**The Rampion Offshore Wind Farm (Amendment) Order 202X**

3. In Article 2 of the 2014 Order, the definition of “footpath stopping up and diversion plan” is amended as follows—

6. Schedule 3 (footpath to be permanently stopped up) is amended as follows—

Footpath diversion consented under The
Rampion Offshore Wind Farm Order 2014

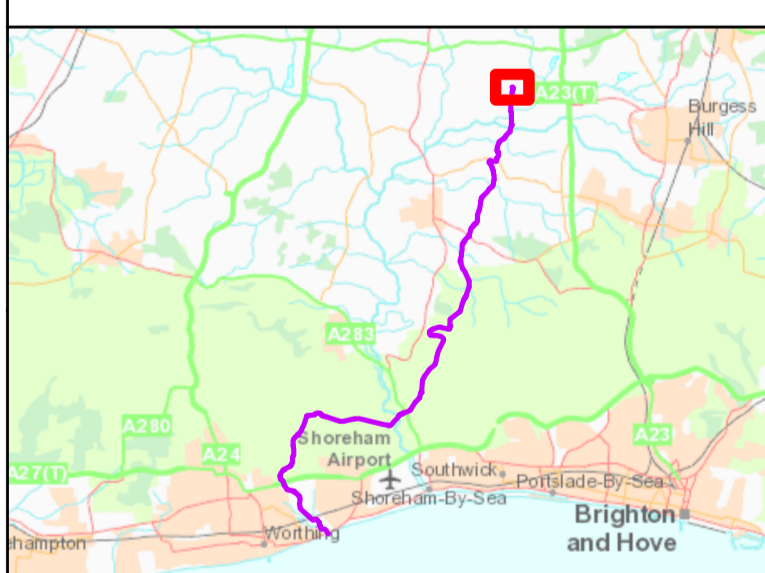
- (a) in column (3) of Schedule 3, for “453 metres” substitute “186 metres”, for “vertical zebra stripes” substitute “black and white dashes” and for “A and E” substitute “A and B”;
- (b) in column (4) of Schedule 3, for “736 metres” substitute “218 metres”, for “black” substitute “solid orange” and for “A, B, C, D and E” substitute “A and B”.

“ “footpath stopping up and diversion plan” means the plan marked as the footpath stopping up and diversion plan and dated 14 October 2020 as substituted by the Secretary of State for the purposes of this Order;”
